Appeal Decision

Appeal Ref: APP/R5510/W/22/3303172

45 Eton Road, Hayes UB3 5HS

PROPOSED GROUND FLOOR
@ 1 : 100

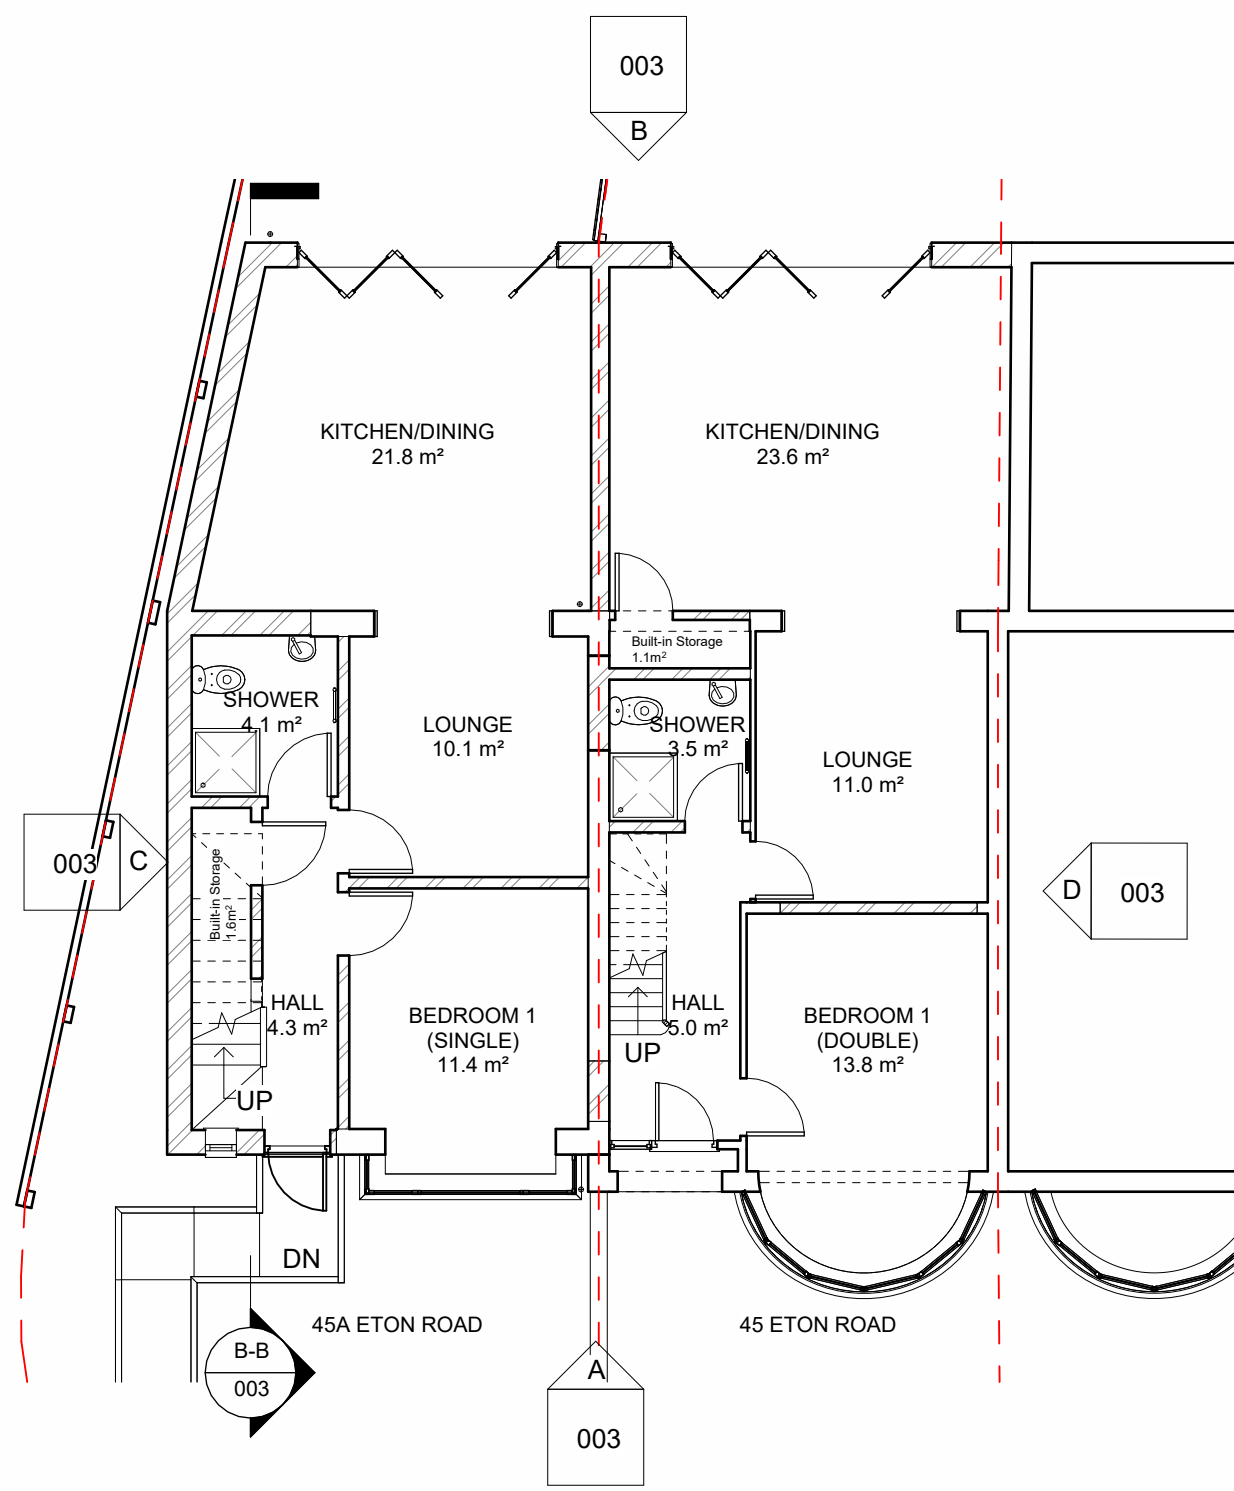
10. The Council considers that the floor area of bedroom 3 does not meet the requirements set out in the Government's 'Technical housing standards – nationally described space standard' and incorporated into the LP under Policy D6, which requires a double bedroom to be at least 11.5m².
11. While the floor plan drawing does indicate a floor area of 11m², it also shows provision of built-in storage of a further 1.2m² which the technical housing standards explains should count towards the floor area requirements. This results in a floor area of 12.2m² for this bedroom and there is no indication that

the minimum room width is not met. The proposal therefore complies with the minimum space standard and LP Policy D6 in this regard. As such, it has not been necessary for me to consider the amended floor plan that accompanied the appeal.

12. The Council's Access Officer suggests that the plans for the proposed dwelling would require a number of amendments to meet the requirements for accessible and adaptable dwellings in LP Policy D7. Amongst the concerns raised was the absence of level access into the dwelling. However, the application drawings clearly show provision of a ramped access. Other internal changes would appear to be relatively minor, such that they could likely have been addressed through planning conditions and the Building Regulations had I been minded to allow the appeal. I am therefore satisfied that the development could achieve compliance with the relevant accessibility standards and thus would comply with LP Policy D7.

PROPOSED SITE LAYOUT PLAN
@ 1 : 200

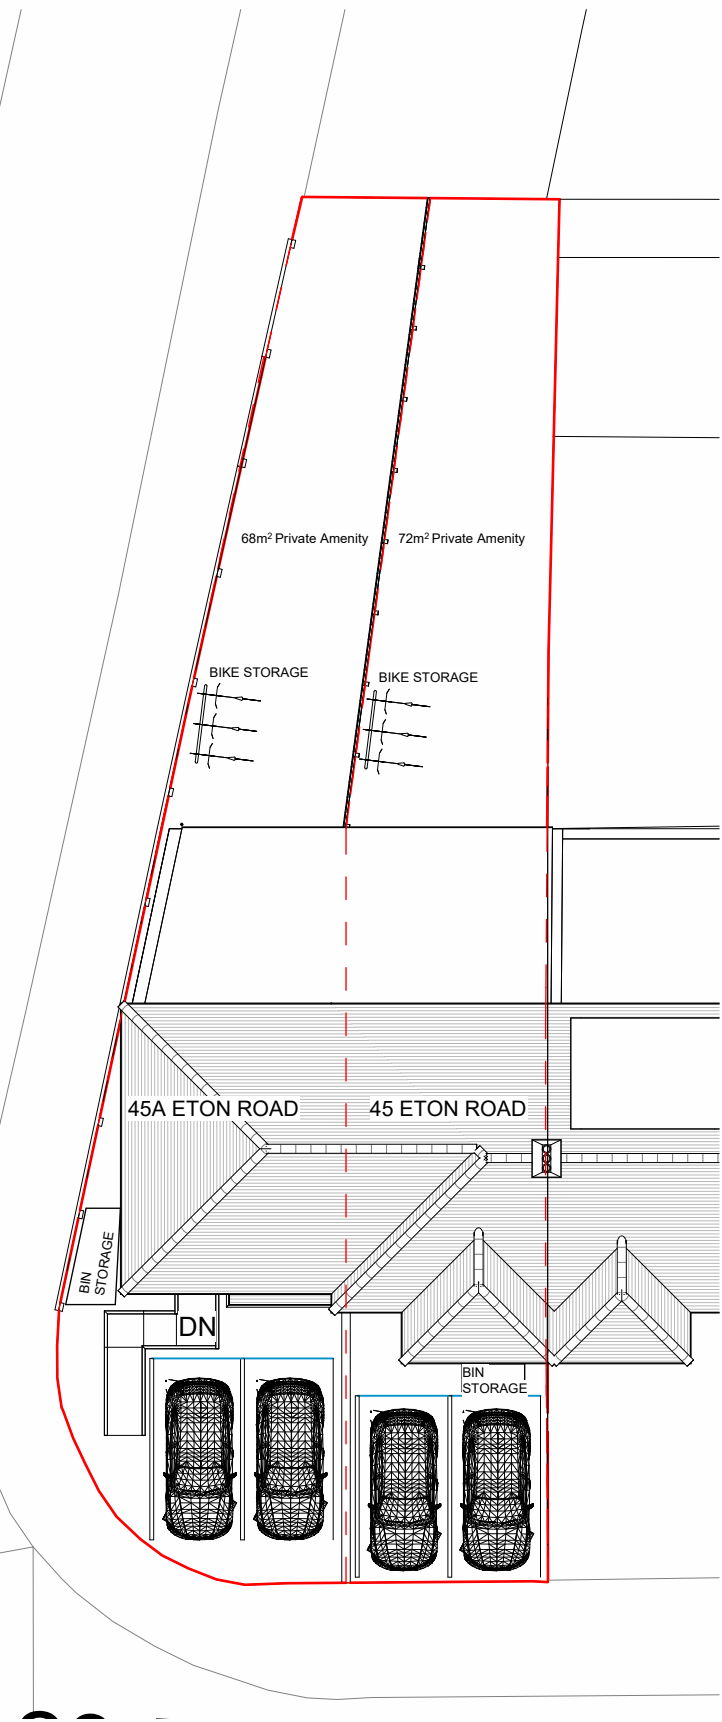
6. The proposal would also see an increase in the amount of hard surfacing and associated car parking across nearly the whole of the site frontage, leaving very little opportunity for any meaningful landscaping to be introduced. This would only serve to reinforce one of the negative characteristics of the area and therefore adds to the overall harm that would arise from the development.

ELEVATION A - PROPOSED FRONT
@ 1 : 100

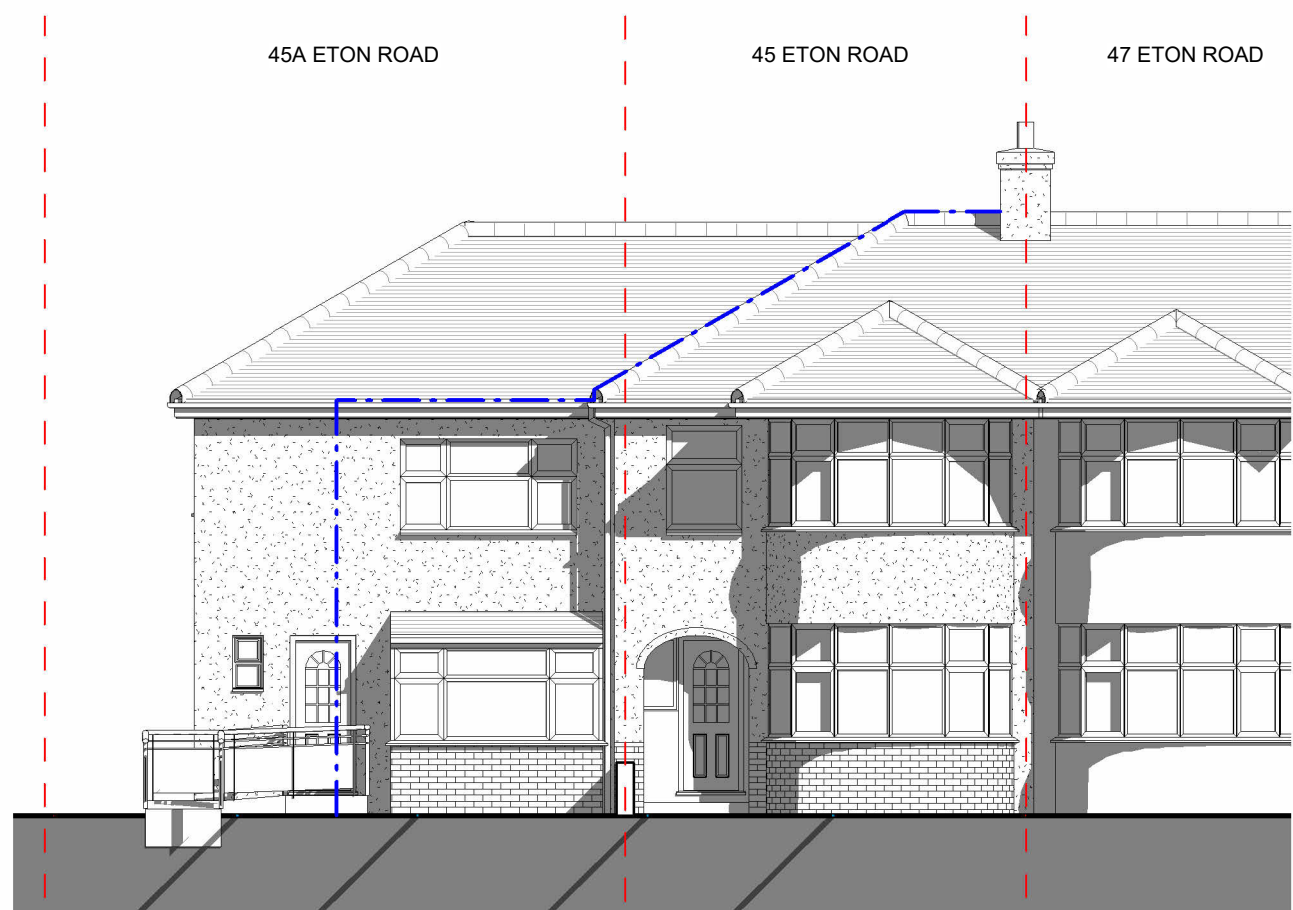
5. In terms of design, I note that much of the original symmetry in the pair of dwellings has already been lost as a result of the existing extensions. Nonetheless, the proposal would add a disproportionately large third element to the existing pair of dwellings. While the front elevation would be set in by a small distance with a corresponding lower roof line, these factors would not be sufficient to overcome the dominance of the development as a result of its width and overall scale in relation to the host building. Additionally, there would be a lack of balance in the composition of its front fenestration compared to the existing pair of dwellings, particularly with a large blank area of wall at first floor level. The overall effect would be a design and scale of development that does not integrate sensitively with the host building and its surroundings.
